A46 Newark Bypass

Scheme Number: TR010065

**Statement of Common Ground With
The Environment Agency**

Regulation Number:	Regulation 5(2)(q)
Planning Inspectorate Scheme Reference	TR010065
Application Document Reference	7.21
Author:	A46 Newark Bypass Project Team, National Highways

Figure 10: Slough Dyke realignment – extract from AS-007 (General Arrangement Plans) Sheet 25005

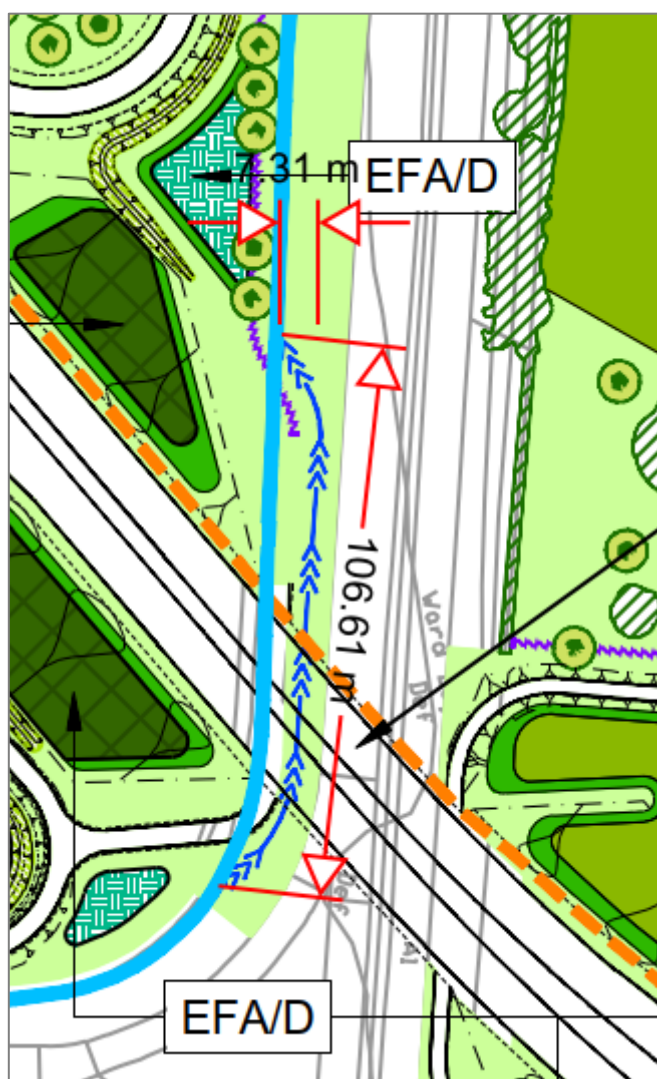
Relevant Representation Reference EAFR-007 (Slough Dyke (main river) realignment) refer to document reference for issue details. No detailed drawings for the Slough Dyke realignment have been provided and the realignment has also not been represented within the hydraulic modelling undertaken. Update at Deadline 2: Within the most recent Hydraulic Modelling Technical Note (as submitted to us for review outside the Examination process), the Applicant has shown that the realignment of Slough Dyke has now been tested within the hydraulic model and confirms no impact on flood risk. No further action is required by the Applicant with regards to testing the Slough Dyke realignment within the hydraulic model. The Hydraulic Modelling Technical Note should be included as appendix of an updated FRA to be submitted as part of the DCO application. While the Applicant has provided sufficient evidence to us to demonstrate that the realignment of Slough Dyke will not have an adverse impact of flood risk, we are still awaiting detailed plans of the proposed river channel in situ. The Environment Agency requires satisfactory cross- sectional plans of the channel and drawings of the channel connecting to the existing channel in order to full resolved this issue. Once a satisfactory revised FRA and plans as mentioned above have been submitted as part of the DCO application, we will be able to resolve this issue. Update at Deadline 4: The Hydraulic Modelling Technical Note as referred to in our WR has now been submitted into the Examination at Deadline 3 [document ref. REP3-034]. This satisfactorily demonstrates that the realignment of Slough Dyke has been tested within the hydraulic model and confirms no impact on flood risk. However, we are still awaiting further detailed plans to clarify the proposed realignment. We acknowledge the Applicant's comments in response to our WR on this issue. However, the issue has since been covered at ISH3 (agenda Item 4 – please see above comments) and note the Applicant intends to provide us	The Applicant welcomes the confirmation that the hydraulic modelling carried out confirms the realignment's hydraulic suitability. All additional flood risk related evidence submitted during the DCO Examination will be appended to the Flood Risk Assessment [APP-177] as appropriate before the closing of the Examination. The Applicant will complete the detailed design of the Scheme following the grant of a DCO for the Scheme. The Applicant has engaged with the Environment Agency regarding the Slough Dyke realignment at flood risk meetings on 05/09/24, 17/10/24 and 27/01/25, providing further details on the proposed plans. On 27/01/25, the draft detailed plans, including a cross-section, for the realignment were discussed with the Environment Agency. At this stage, it is suggested that securing the Environment Agency as a consultee on the design of the Slough Dyke realignment is appropriate. The Applicant welcomes the Environment Agency's further comments on this item. The Applicant has submitted draft detailed design drawings of the Slough Dyke realignment to the Environment Agency who have requested an amendment to the design through the removal of reno mattress and replacement with appropriately sized riprap for erosion control and embankment stability. The updated design will be provided to the Environment Agency who have agreed that this can be submitted as part of the flood risk activity permit application for the Slough Dyke realignment works.	Agreed	19/02/2025
